**From:** [Downes, Scott G \(DFW\)](#)  
**To:** [Kelly Bacon \(CD\)](#); [White, Lori \(ECY\)](#)  
**Cc:** [Torrey, Elizabeth M \(DFW\)](#)  
**Subject:** RE: Sweetwater Site Plan Amendments  
**Date:** Tuesday, July 13, 2021 1:48:09 PM

**From:** Kelly Bacon (CD) <kelly.bacon.cd@co.kittitas.wa.us>  
**Sent:** Tuesday, July 13, 2021 7:51 AM  
**To:** White, Lori (ECY) <lowh461@ECY.WA.GOV>; Downes, Scott G (DFW) <Scott.Downes@dfw.wa.gov>  
**Subject:** Sweetwater Site Plan Amendments

Revised Site Plan
 Submittal Date
 6-11-21

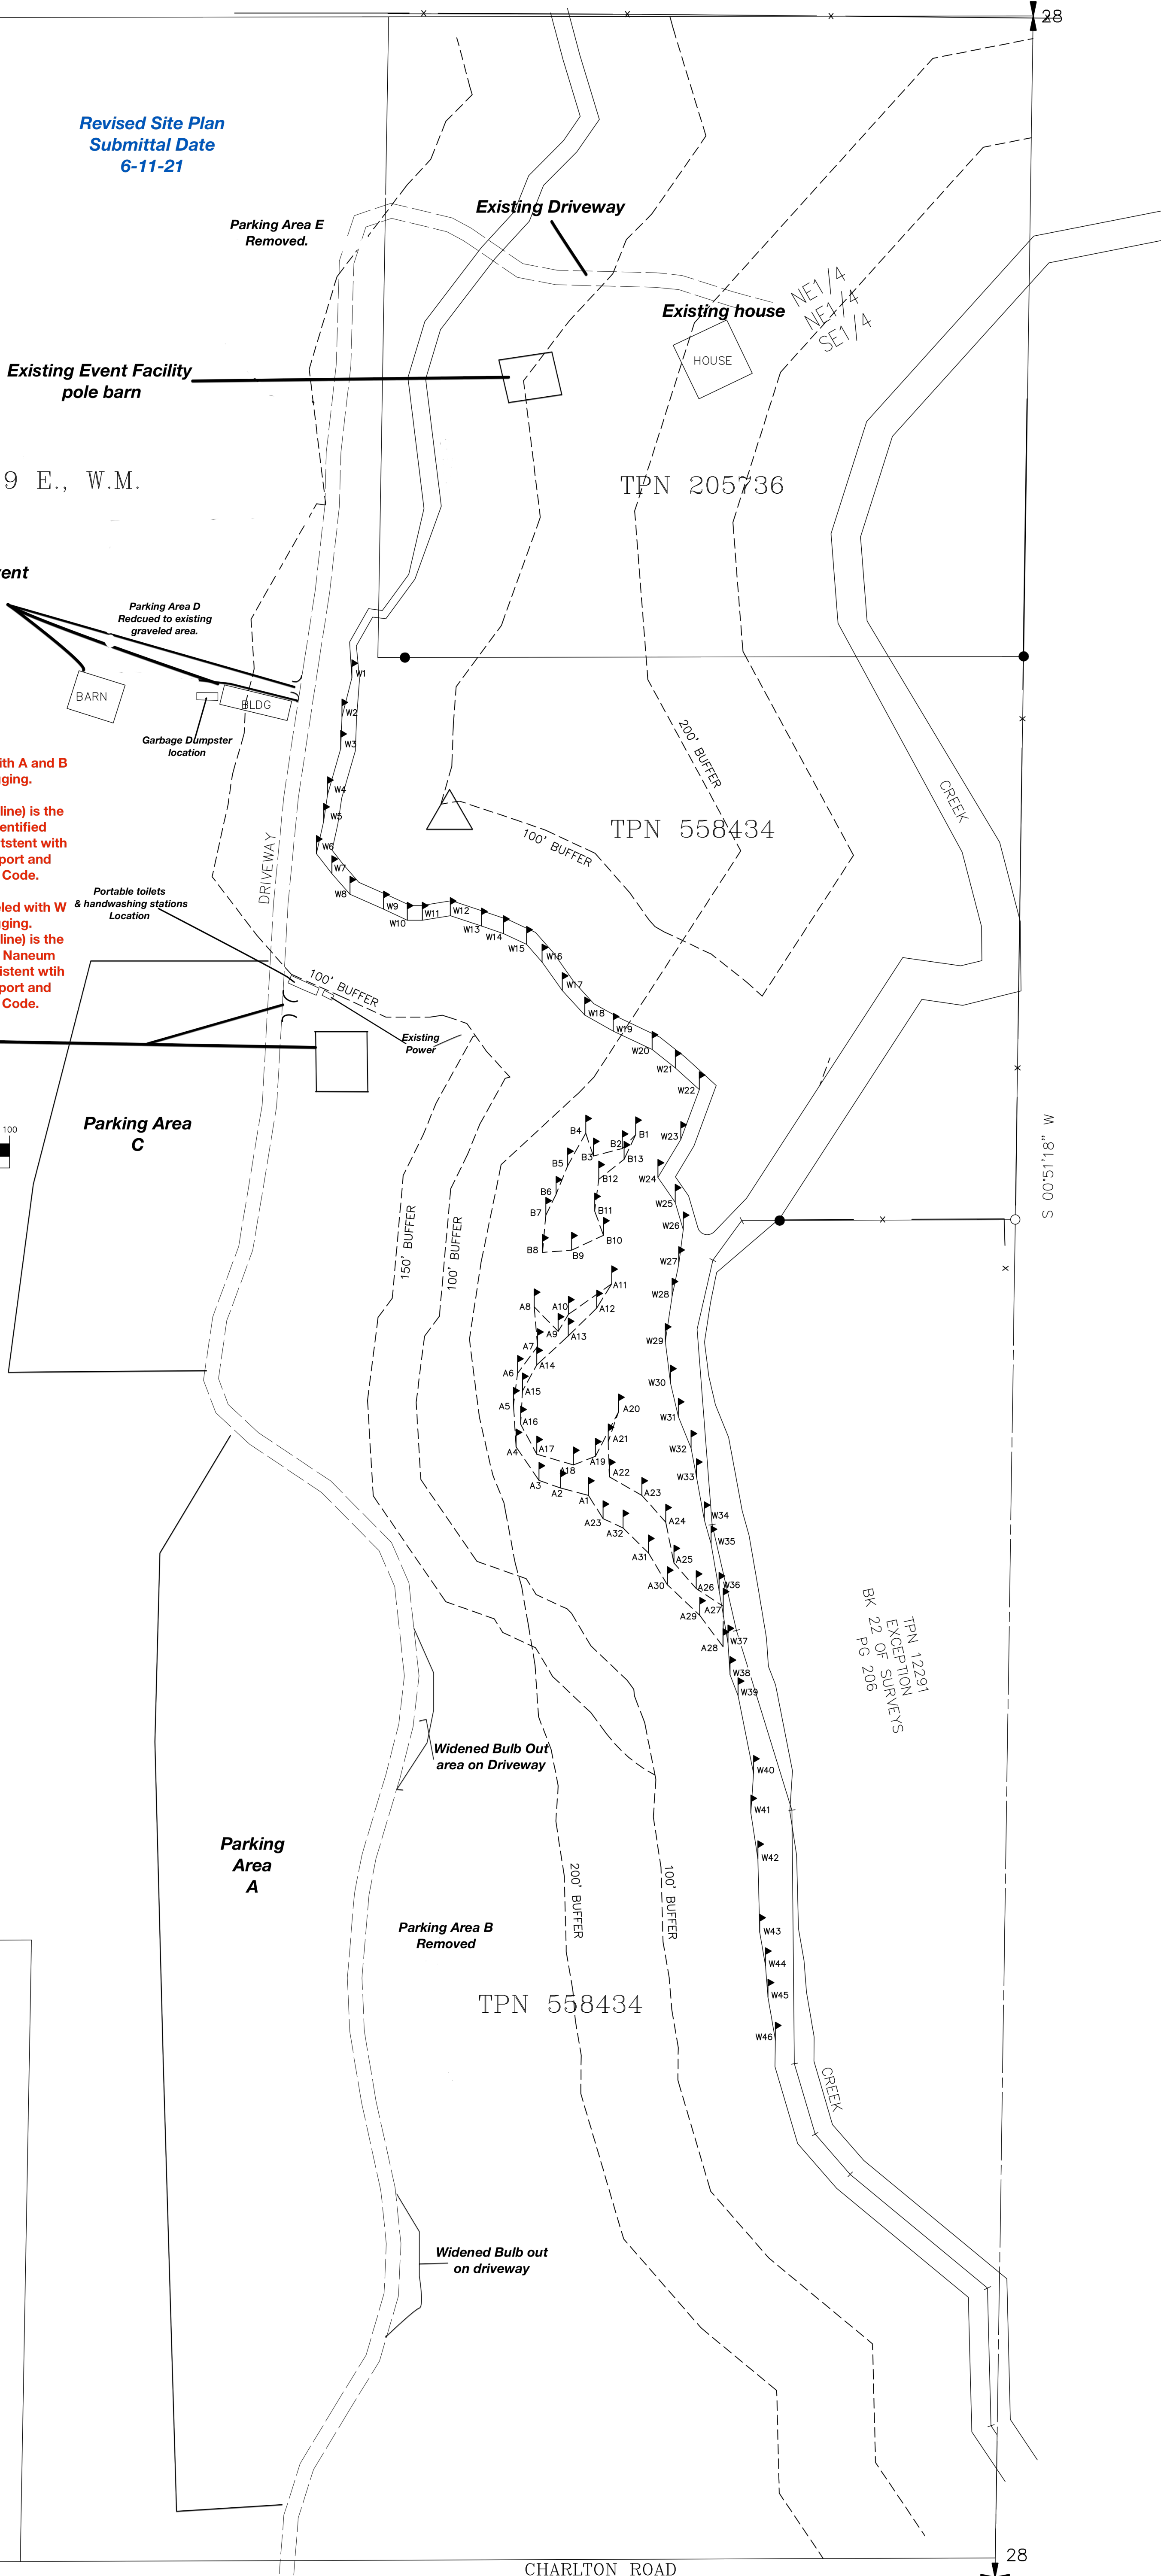
Thank you for arranging the site meeting today. Thanks to the applicants modified site plan where they are now completely avoiding impacts to existing shrubsteppe habitat, WDFW feels that issue is resolved. Our other comments regarding firewising and riparian management were more guidance in nature as the county and Ecology have more formal jurisdiction. If either entity needs our help with those issues, we are willing to assist.
